Development: Erection of single storey rear conservatory. (This application may affect the character and appearance of the North Bersted Conservation Area and a Listed Building).

Location: Dove Cottage 76 North Bersted Street Bersted PO22 9AQ

I regret that I am unable to accept your documents as a valid application until the following item(s) have been received or resolved :-

East elevation

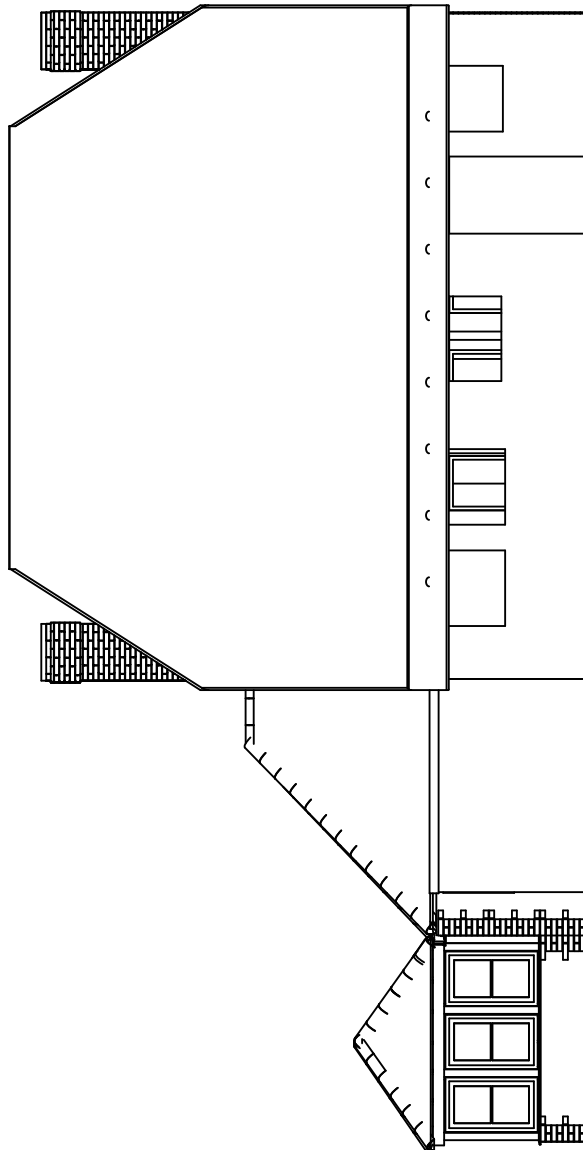
Please submit the proposed side elevations at a scale of 1:50 or 1:100. The proposed rear elevation must also show the existing rear window displayed on the proposed floor plan. Along with this, please add a scale bar to the proposed floor plans and elevations. Further details can be found in the Validation Requirements List.

Location Plan - Erection of conservatory

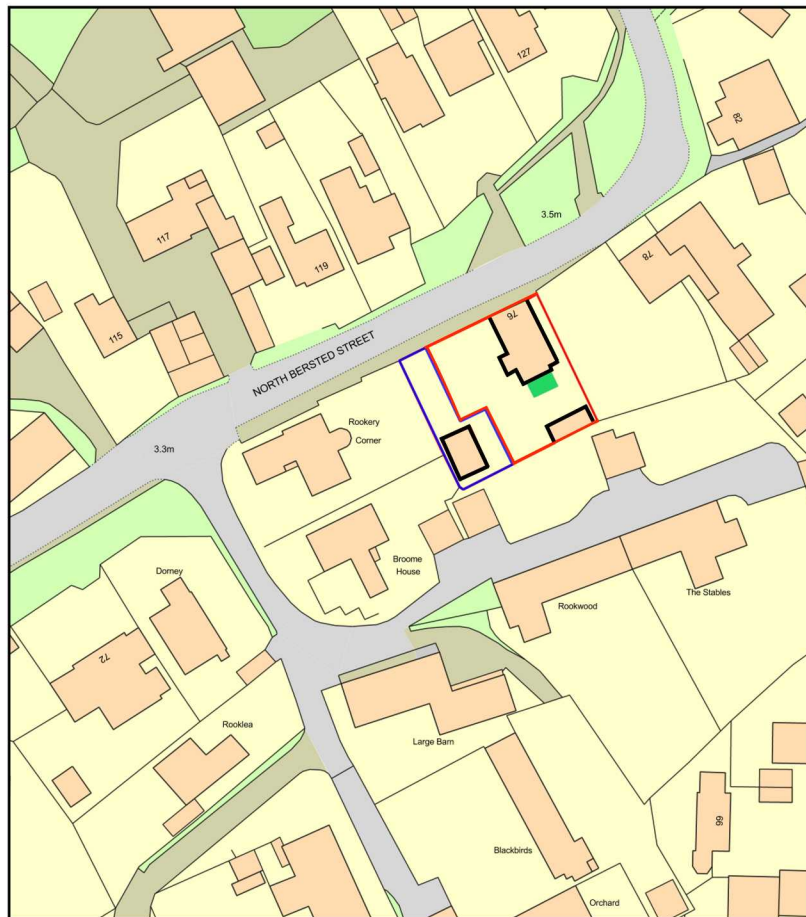
Please submit an electronic location plan in pdf format at a scale of 1:1250 or 1:2500 for rural areas. Further details of what must be included on the plan can be found in the Validation Requirements List.

Erection of conservatory

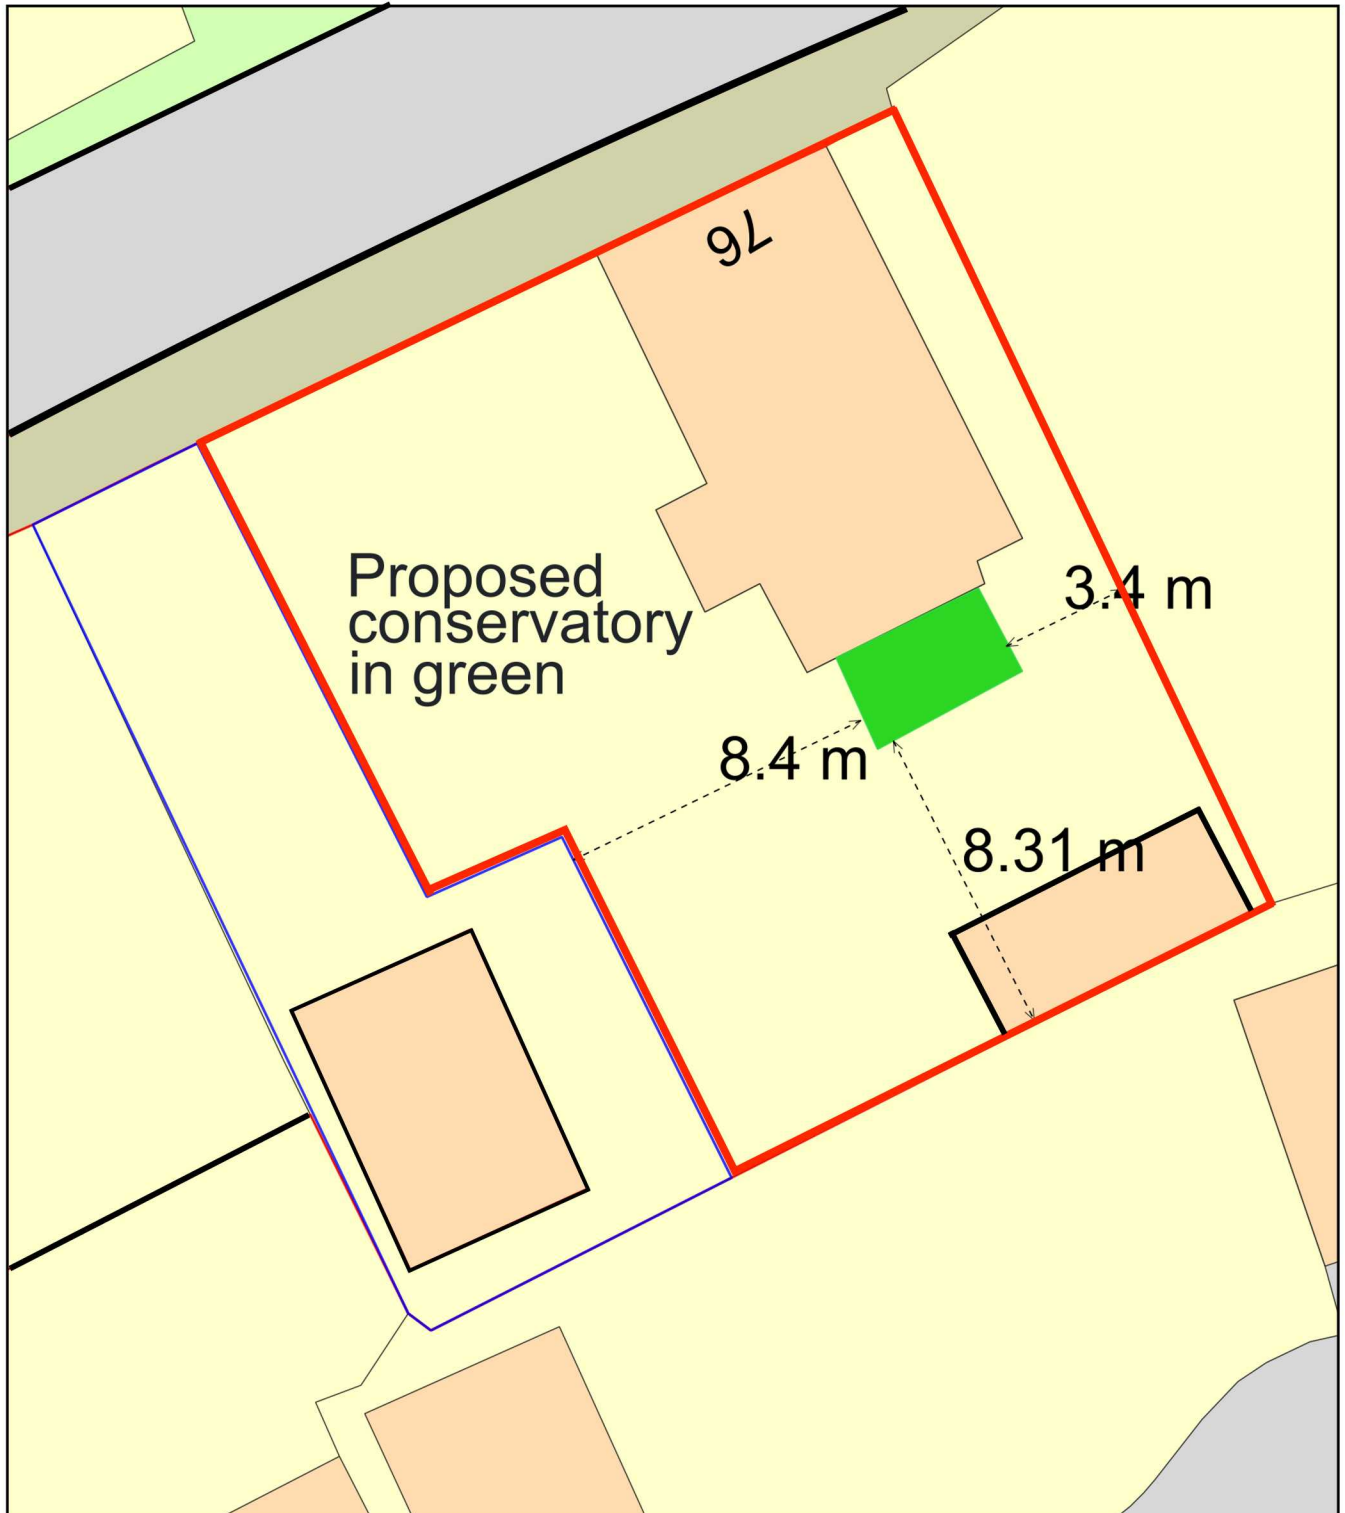
Please submit an electronic block plan with dimensions from the proposed extension to all site boundaries in pdf format at a scale of 1:500. Further details of what must be included on the plan can be found in the Validation Requirements List.
